REF: AS11489.210504.L2

AS11489 LAND NORTH OF MAYFLOWER WAY, ANGMERING**Planning Condition 19**

Crayfern Homes Ltd proposes to develop the land north of Mayflower Way, Angmering for residential accommodation comprising a total of 24 new dwellings, subject to the following planning condition (application ref. A/46/19/PL):

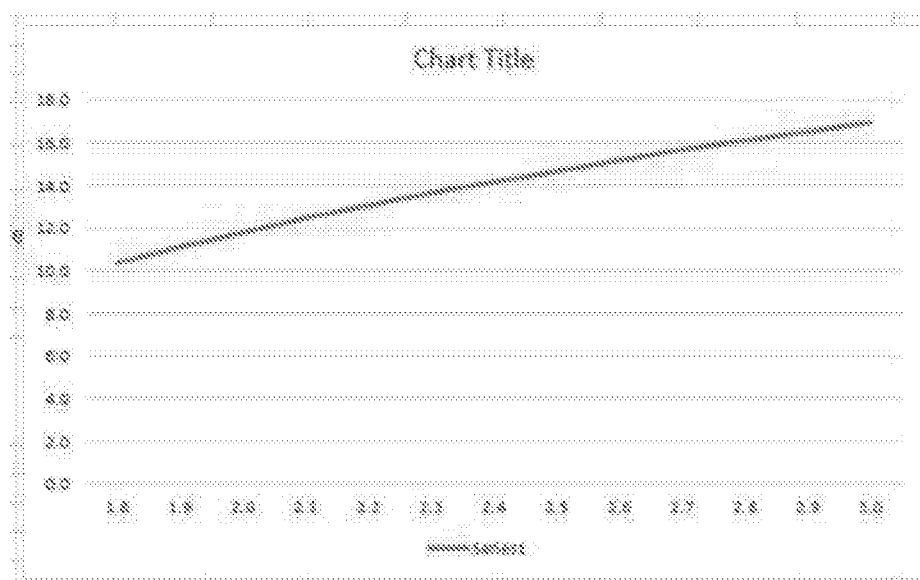
However, the Environmental Health officer has advised that the proposal for a system of Daikin Air Source Heat Pumps which will be provided at each unit of accommodation can include external fans and pumps which has been associated with adverse noise to the detriment of neighbouring residential units.

It is therefore recommended that the Acoustic Report required under Condition 19 of the original Application A/46/19/PL includes investigation of this equipment to assess its likely effect on the acoustic environment and whether this is suitable in this case."

With regards to plots 12 and 15, calculations suggest absolute noise levels generated by the air source heat pumps could be up to 2 and 3 dB higher than the typical background noise levels respectively. BS4142:2014 advises that this is below level where it is indicated that adverse impact may arise depending upon context. It should be noted that the above calculations are based on the air source heat pumps running at maximum capacity and are unlikely to reach these noise levels during the night-time period (23:00 – 07:00), when heating requirements are reduced. In addition, the absolute levels are very low. With allowance for approximately 15dB attenuation for a partially open window, internal noise levels are significantly lower than desirable internal noise levels in BS8233:2014.

It is, therefore, anticipated that the proposed plant selection and layout is unlikely to have an adverse effect on the acoustic environment, thus Condition 19 can be discharged.
